**Westpark Warehouse Facility (SSD-4953-Mod-2)  
Response to Submissions**

## Attachment A

### Dangerous Goods

Figure 3-4: DG Cage Storage Configuration

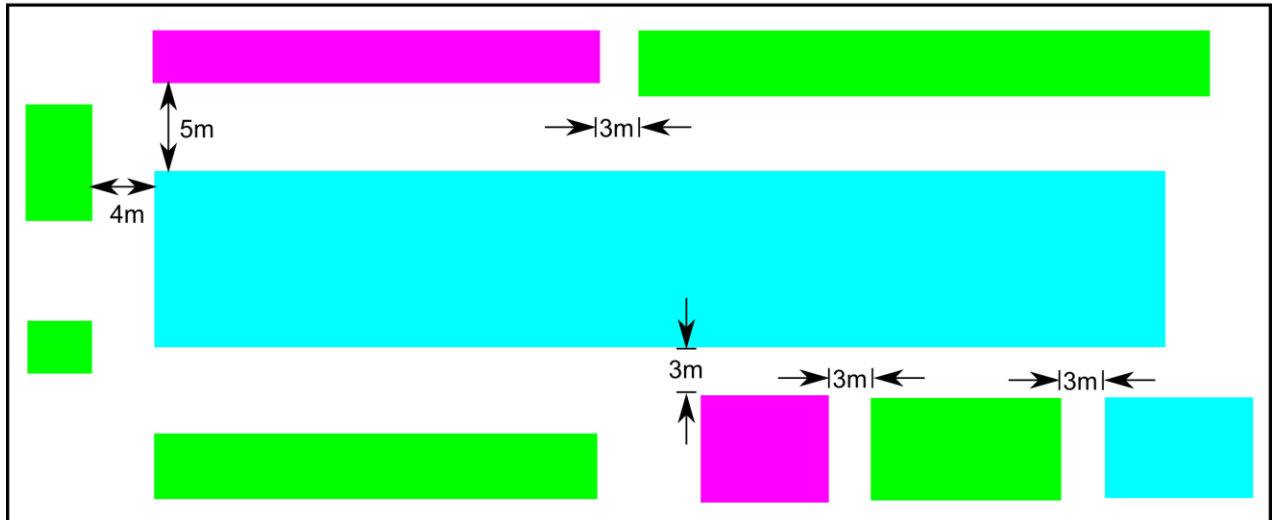
4. Figure 3-4 of the Preliminary Hazard Analysis (PHA) does not indicate the location of the DG Class 4.1 material. Please provide an updated figure indicating the location of this material.
